Response to Submissions – 554-562 Reservoir Road, Prospect (SSD-9577613)

This letter, in relation to Americold Prospect South Expansion (SSD-9577613), details the response to submission following the conclusion of the exhibition period for the application on 8 December 2022 and responds to the Further Issues Letter received from the Department of Planning and Environment, dated 21 December 2022.

Application SSD-9577613 proposes to construct an extension to its existing temperature-controlled warehouse facility at 554-562 Reservoir Road, Prospect NSW, including a 5,140m² extension to the east of the existing southern warehouse, reconfiguration of the existing carparking and driveways to improve truck movement, access and loading arrangements within the site, and construction of ancillary buildings and plant.

Discipline: CIVIL
Drawing No: 2444390-DWG-CA-0004
Beca Project Number: 2444390-DWG-CA-0004

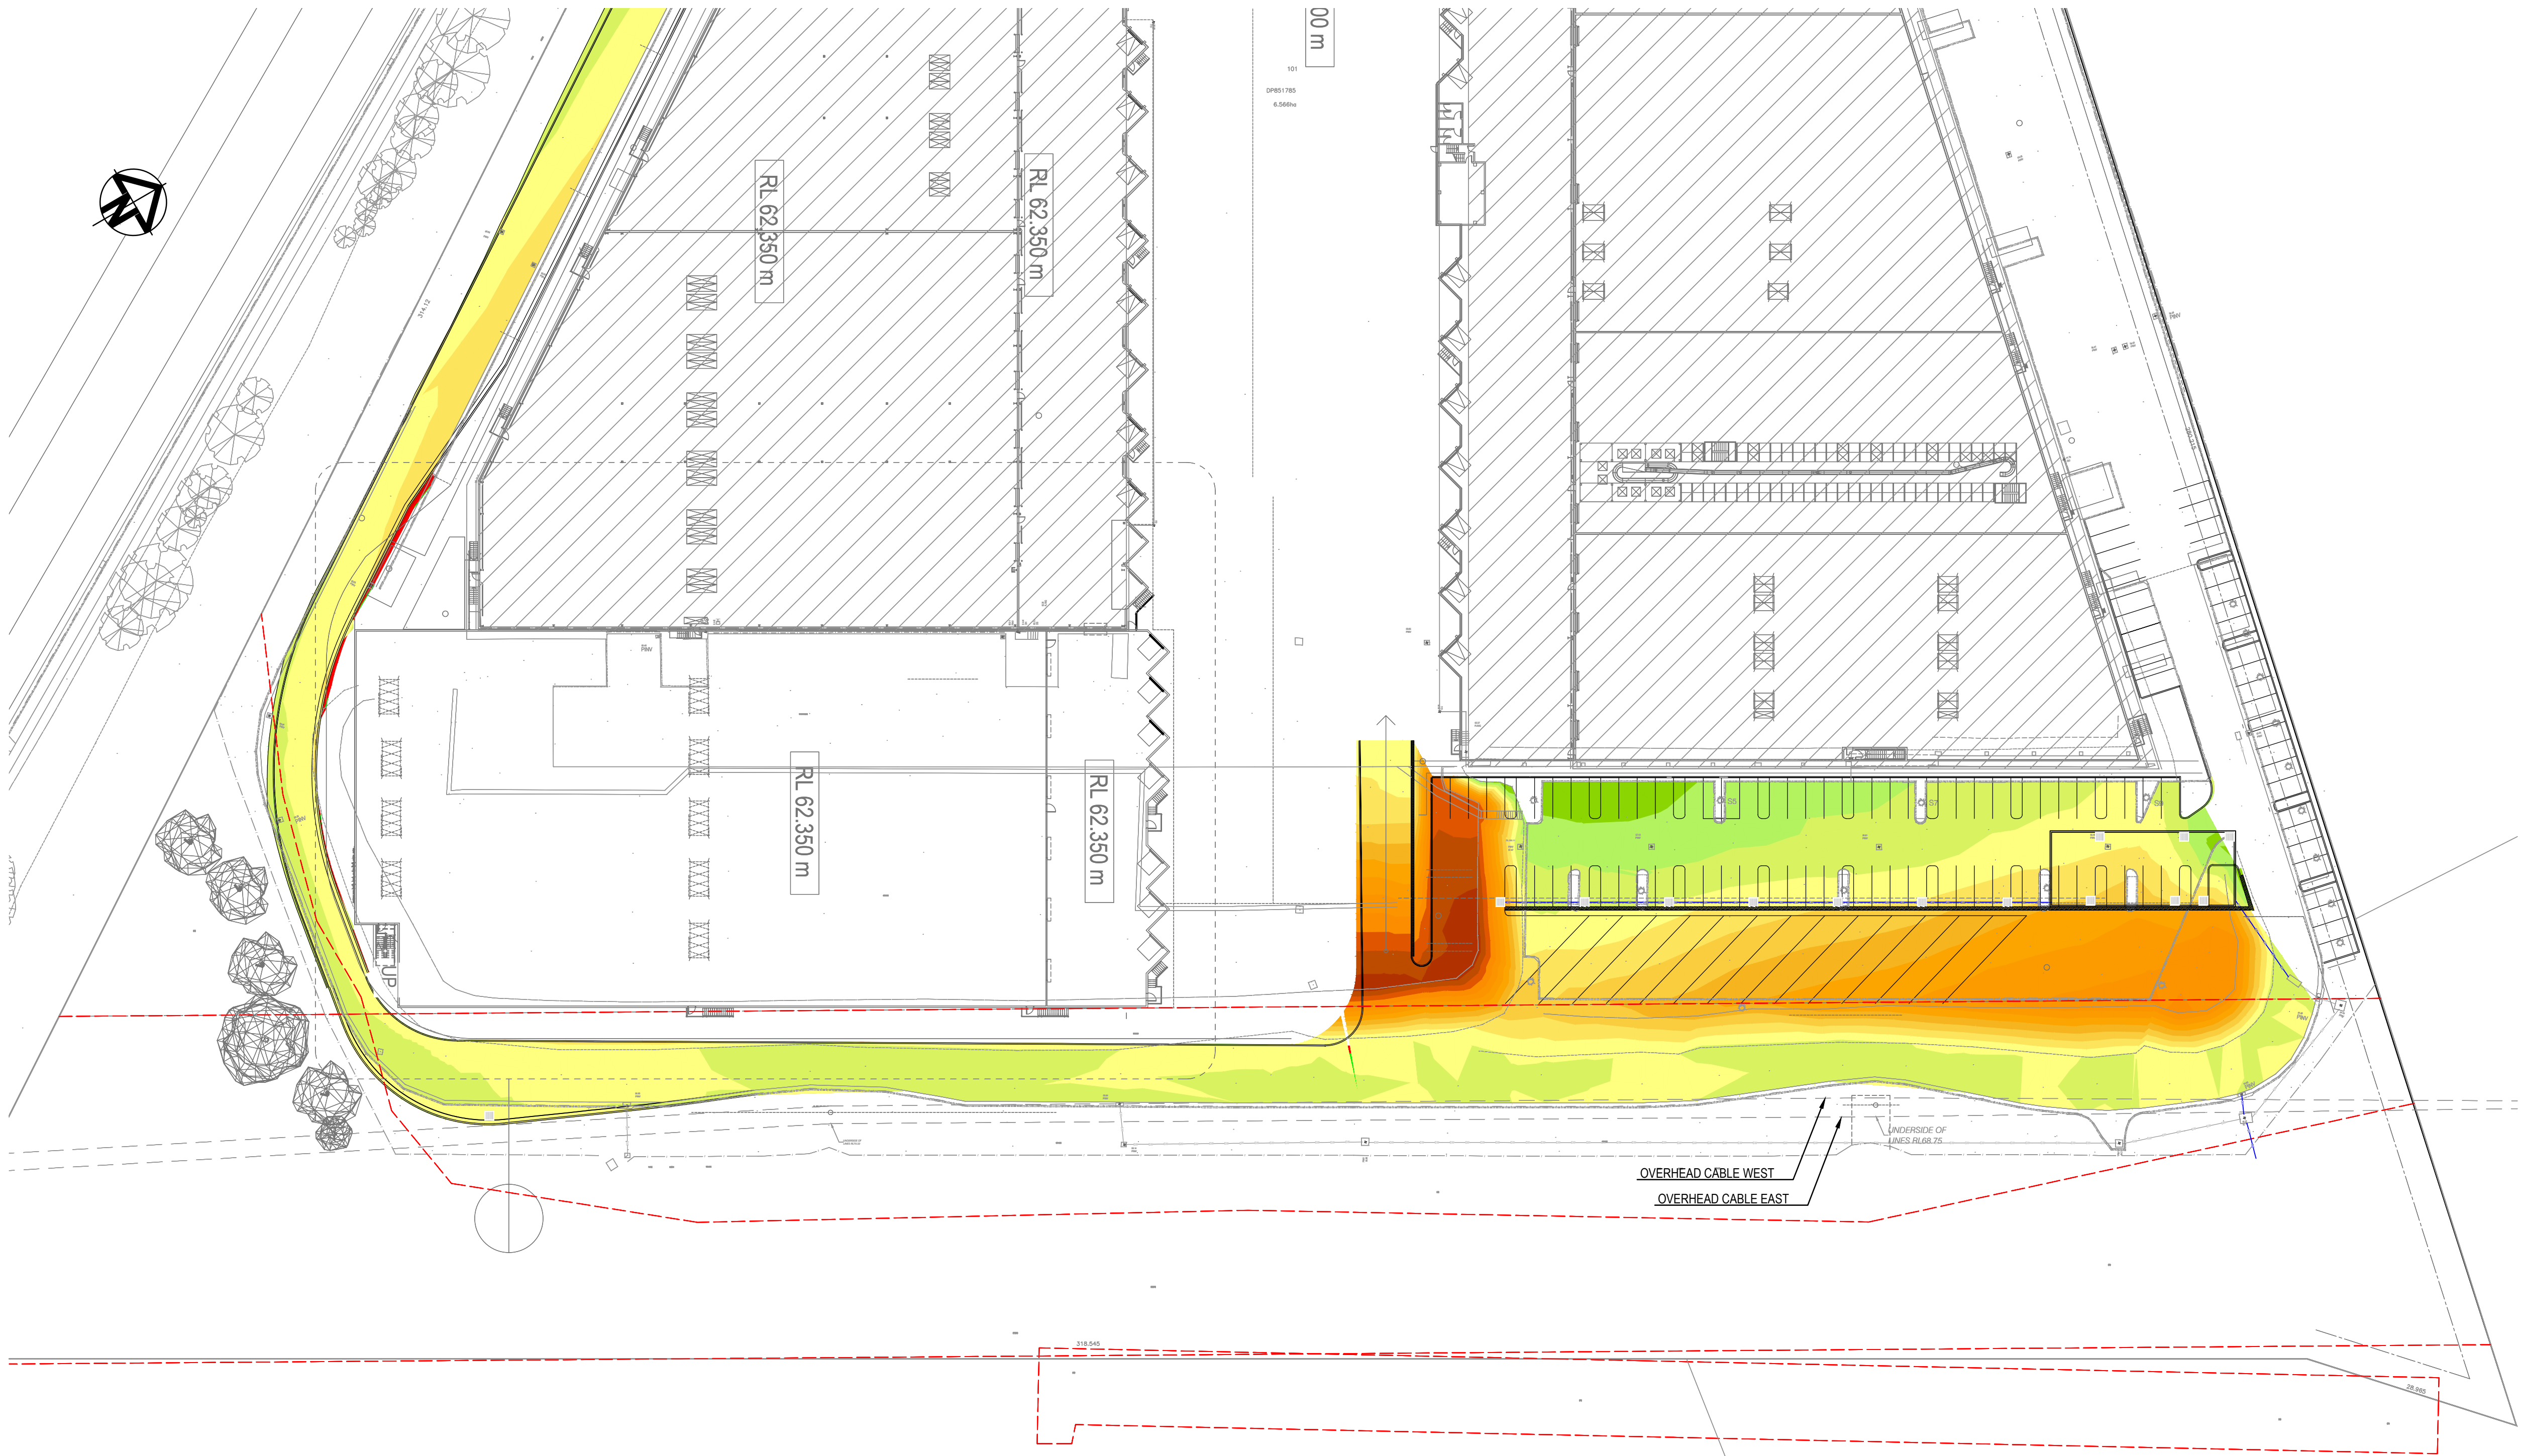
Comments	Responses	Changes to EIS
The stormwater drainage plan indicates that the OSD system has not been designed according to the Upper Parramatta River Catchment Trust's (UPRCT) design guidelines. All the runoff must be directed into the High Early discharge (HED) control chamber/pit for efficient functioning of the OSD system. The stormwater plan indicates that the OSD tank does not incorporate the HED chamber. Further, the lack of high early discharge will result in storage being filled earlier than needed and undermine the functionality and efficiency of the OSD system.	The OSD system has been updated to include an HED chamber. Additionally, the overall OSD system has been split into two tanks to optimise system layout and improve system efficiency.	Refer to updated Stormwater Management Plan and Drawings.
Based on the submitted plans, the development site area is noted to be over 1.3ha which includes the new trailer parking area, the associated access driveway and the landscape area. Based on this, the OSD storage requirement for the proposed development to control the site runoff/flow in accordance with the UPRCT guidelines would be approx. 625 cubic metres.	Noting the additional impervious areas added to the site a PSD has been developed according to the requirements of the UPRCT. An overall OSD volume of 450m ³ of storage has been provided with calculations (DRAINS modelling) to support this shown on DWG CA-0901 and in the Stormwater Management Plan included in the EIS. This volume has been optimised by capturing roof runoff to offset new impervious areas.

The levels (grate levels and invert levels) of the surface collection pits the upstream and downstream side invert level of the associated pipes including ground level have not been provided. Nevertheless, the pipes must be installed in the falling gradient towards the OSD system.	Annotations showing pit name, cover level and invert level have been added to DWG CA-0701,2,3,4. All pipes have adequate gradient to an OSD or site outlet.	
For clarity and referencing, each of the pits must be numbered appropriately with the associated surface and invert levels shown adjacent to the pit. In addition, each of the drawings must have standard reduction scale shown appropriately on the drawings.	Annotations showing pit name, cover level and invert level have been added to DWG CA-0701,2,3,4. All pipes have adequate gradient to an OSD or site outlet. Relevant plan scales have been added.	
All the runoff that is directed into the OSD system must be directed into the HED control chamber/pit. The submitted plans do not demonstrate the requirements.	Refer above comment, OSD arrangement has been modified and HED control chambers have been incorporated.

Comments	Responses	Changes to EIS
The Top Water Level (TWL) of RL55.53 within the OSD tank as shown on the cross-sectional drawing is not achievable as the top water level is controlled by the spillway level of the Overflow Weir which is lower than nominated TWL. The actual water level cannot rise above this i.e., RL 55.40m AHD. Hence, the volume calculation for the provided OSD storage volume appears to be overestimated.	<p>The on-site detention system has been revised to incorporate the above comments and is detailed on the updated drawing set.</p> <p>All relevant control levels, weirs and outlet orifices are detailed in the updated drawing set.</p>	Nil
Stormwater Management - Water Sensitive Urban Design (WSUD) measures		
<p>The submitted stormwater plans do not appear to incorporate the WSUD measures nor demonstrate how the pollutants removal targets, objectives and control as outlined in section 2.5 and 2.7 Part G4 of Cumberland DCP 2021 are met. The stormwater drainage plan shall be amended to incorporate the water sensitive urban design (WSUD) measure in accordance with the Section 2.5 (Water Quality objective and control) under Part G4 of Cumberland DCP 2021 including water quality improvement and water reuse measures. In this regard, the following matters shall be addressed:</p> <p>i.) Detail drawings demonstrating the Water sensitive Urban design measures (Water quality treatment/ improvement measures) consistent with the council's policy shall be provided.</p> <p>ii.) The surface runoff from the impervious area such as the roof, car parking area, driveway and roads shall be directed to the water quality treatment systems. In this regard, appropriate measures to collect and treat the runoff to remove pollutants shall be implemented. The printout of the MUSIC Model layout noted in the submitted documents. However, drawings/plans showing the incorporation of the layout and details of the water quality treatment systems have not been noted/provided.</p>	<p>WSUD elements have been revised and detailed to show compliance with G4 of the Cumberland DCP.</p> <p>The drawings have been updated to include:</p> <p>i) Details of Ocean Protect treatment devices.</p> <p>ii) Details and layout of the treatment devices has been added to the plans to allow treatment of all new hardstand areas. Updated MUSIC modelling and description of the system has also been incorporated into the Stormwater report.</p> <p>iii) Catchment areas are detailed on DWG CA-0901.</p> <p>iv) Treatment measures within OSDs have been designed in consultation with Ocean Protect to ensure that the system meets common practice and standards used in Cumberland.</p> <p>Details showing quality devices and their incorporation into the Stormwater System have been added to the drawing set. These have been developed with Ocean Protect to ensure that their products have been incorporated such that treatment trains are optimised and function in coordination with the stormwater pipe network and OSDs. This design incorporates the items raised and experience from other Cumberland approvals to meet WSUD objectives.</p>	<p>Updated Section 7.4 with additional information to respond to Stormwater Management comments.</p> <p>Refer to updated Stormwater Management Plan and Drawings.</p>

01 PARKING BAYS - LAYOUT A
7001 1:50

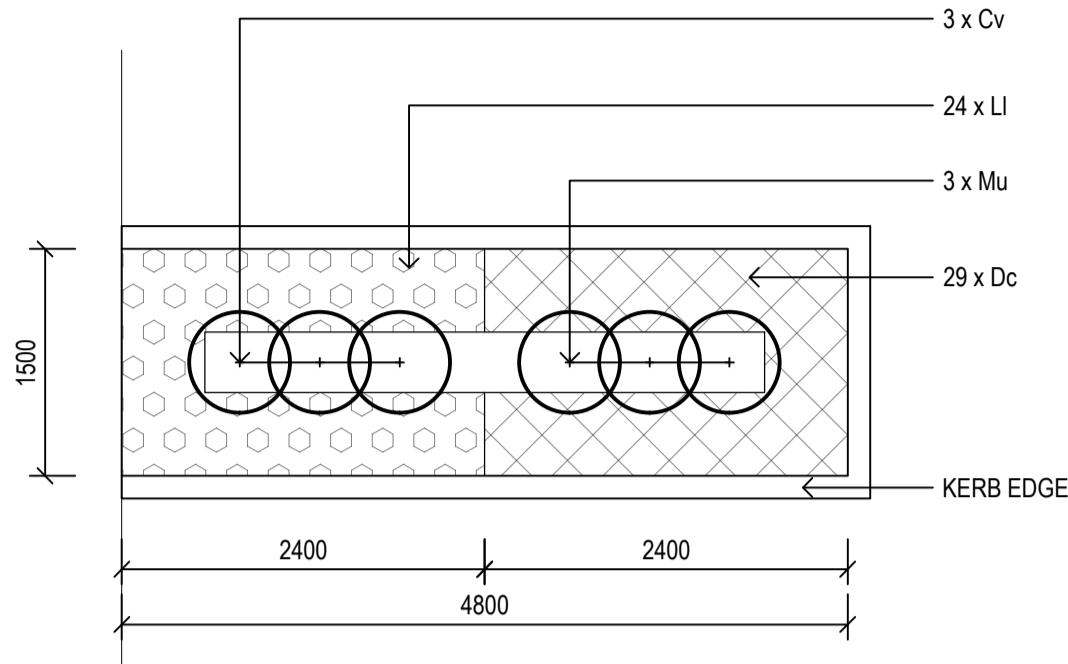
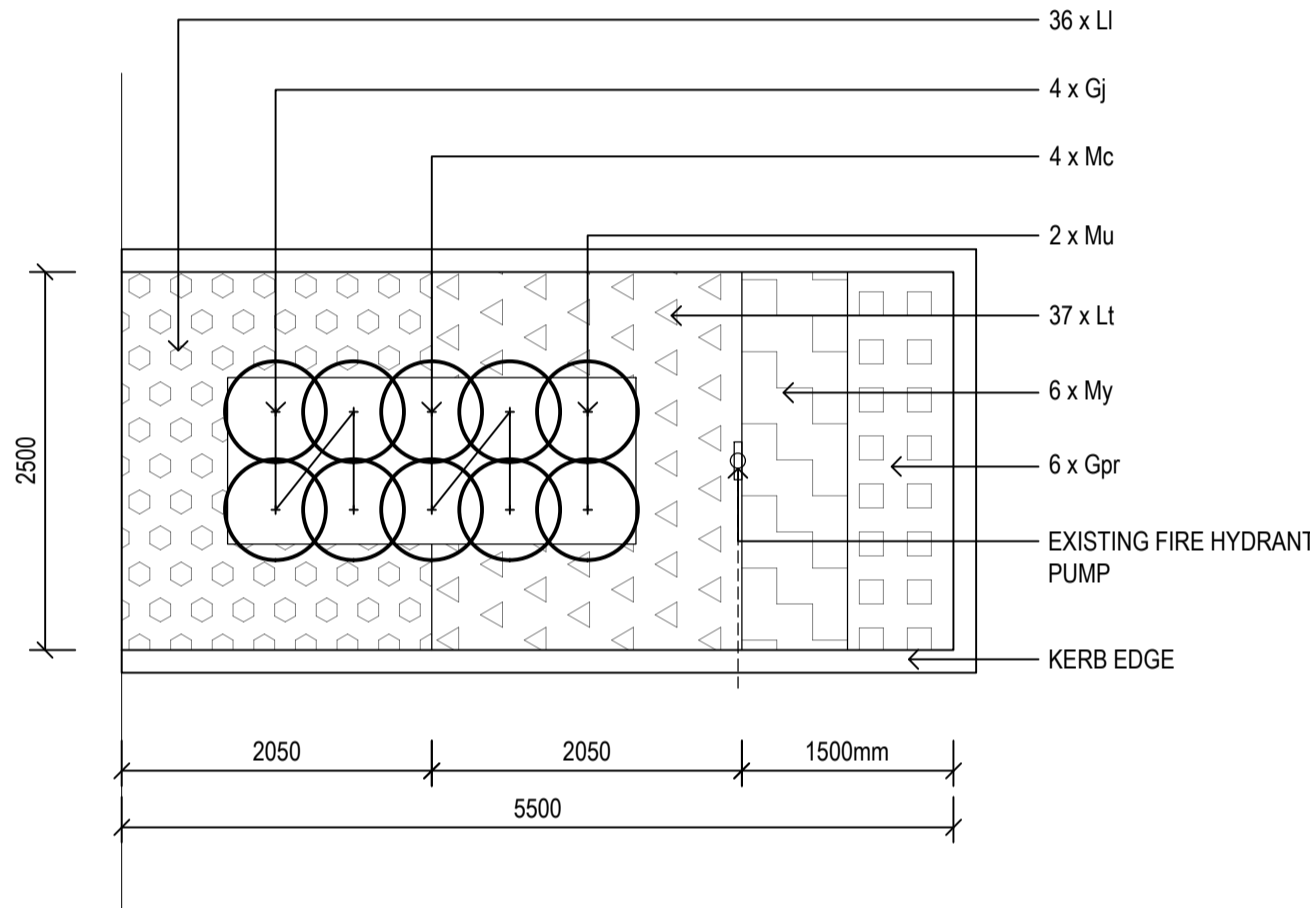
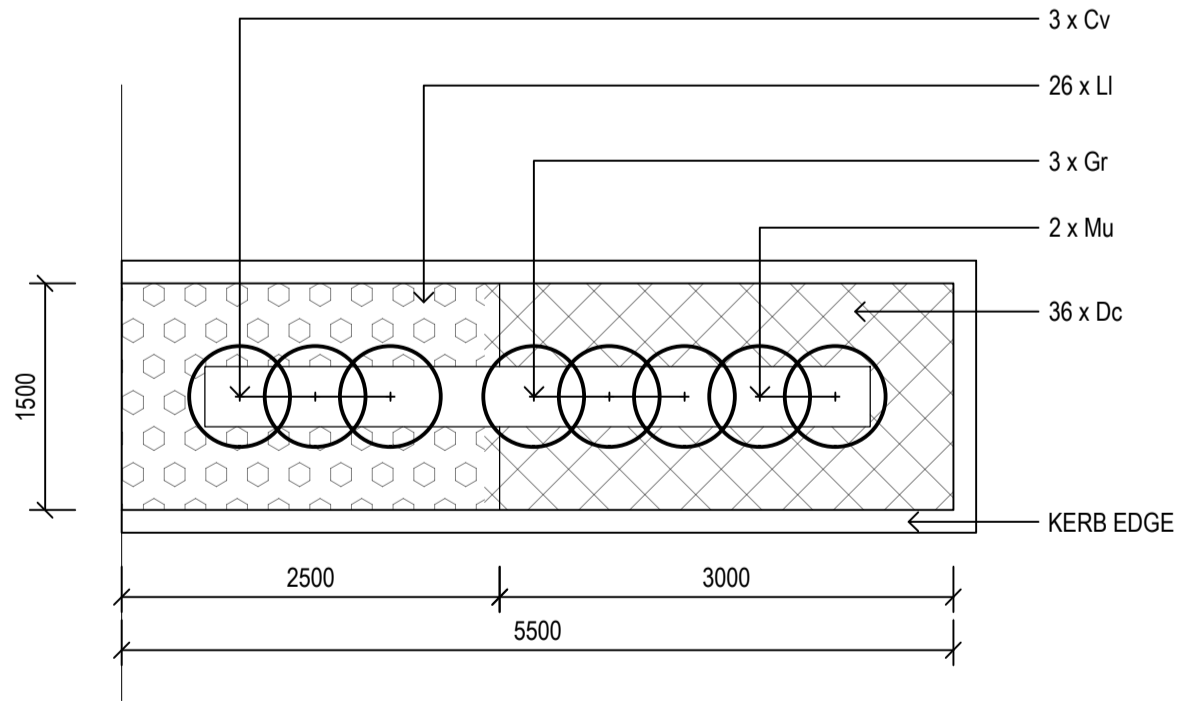
Comments	Responses	Changes to EIS
<p>As per the submitted Traffic Impact Assessment report, the parking provision made appears to satisfy the requirement. However, the following comments are made:</p> <ul style="list-style-type: none"> Each of the parking spaces must be appropriately numbered and dimensioned. The existing 21 visitor's car spaces that is proposed to be deleted must be made available from the new car parking area/provision and clearly marked and signposted. 	<p>Comment noted.</p> <p>All carparking will be constructed to the appropriate standard including dimensions, marking and signage.</p>	Nil
Planning		
<p>There are no building height controls for the subject site under Cumberland LEP 2021. Further, Pursuant to Clause 2.10 of the Planning Systems SEPP, the Cumberland Development Control Plan (Cumberland DCP) does not apply to the proposed development. Notwithstanding, a general commentary is provided on the proposed development as below:</p> <p><u>Cumberland DCP 2021</u></p> <ul style="list-style-type: none"> - Part D Development in Industrial zones - Part F3- Industrial Site Specific <p>Given the proposed building (south cold storage expansion) proposes a significant height as compared to the existing building, the structure shall incorporate articulation in building facades and variety in building materials and finishes to minimise the overall visual impact of the proposed structures as viewed from the street and be sympathetic to the existing heritage site – the Prospect Hill State Heritage Registered area.</p> <p>The overall design shall be compatible with the existing built form and streetscape in terms of façade treatment, building materials and finishes.</p>	<p>As noted by Council pursuant to Clause 2.10 of the Planning Systems SEPP, the Cumberland Development Control Plan (Cumberland DCP) does not apply to the proposed development.</p> <p>Despite this, the proposed development has been designed to be compatible with the existing built form and streetscape in terms of façade treatment, building materials and finishes, in keeping with the industrial nature of the site and location and is responsive to the environmental features nearby resulting in limited amenity impacts.</p> <p>Further to this, to enhance urban design outcomes, enhanced site landscaping is proposed to provide suitable screening sympathetic to the surrounding area and features.</p>	Nil
